04/07/2019

Modification 2 Removal of ground slabs and existing piles (SSD-9249-Mod-2)
Request for Additional Information

ATTACHMENT 1

Figure 4.2: Sydney Water Diversion Plan showing existing stormwater main (thin blue line), and proposed (thicker blue line) (Source: Aurecon 2019, DWG-CC-00041-B, 25.4.19)

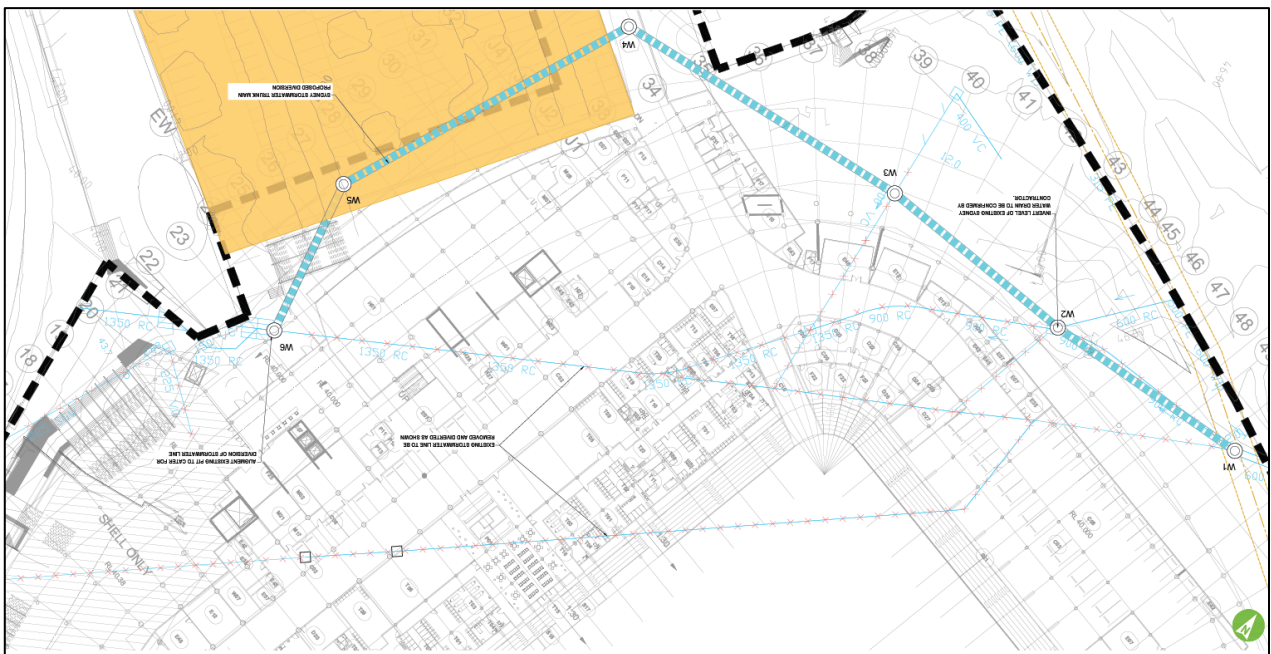
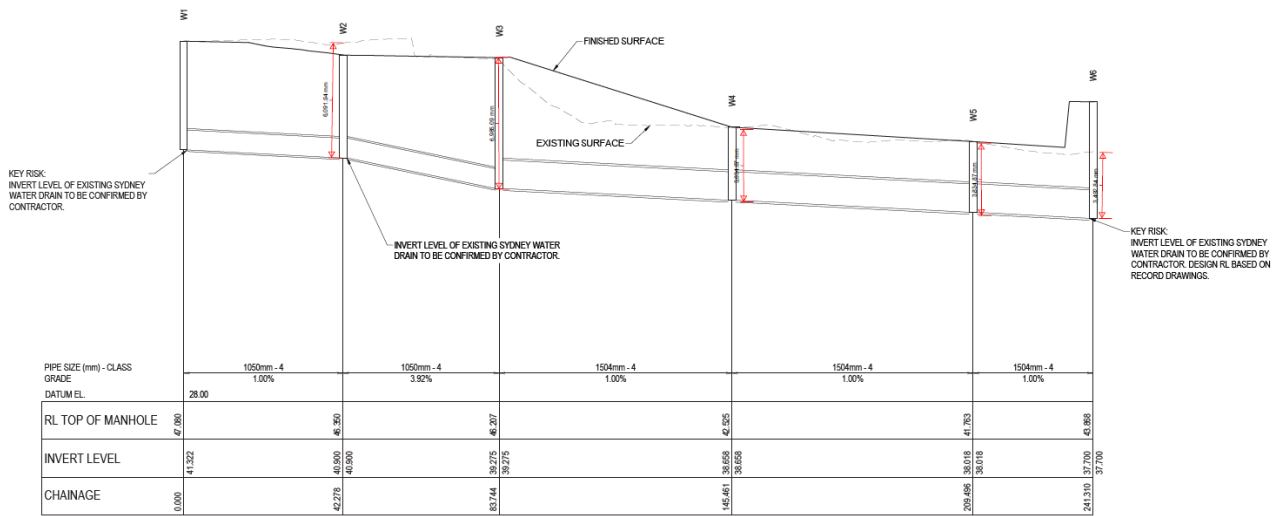
- The AAIS proposes monitoring during the trenching for the stormwater diversion. However, it should include the removal of historic fill, including removal of objects found (if any) and then testing of the area to be trenched, in case of natural soil profiles being present. Depending on the findings of the testing, significant features should be explored (to the full extent of the feature) or salvage expansion should be undertaken. The methodology should be amended and resubmitted to reflect these requirements and be consistent with the ACHAR.
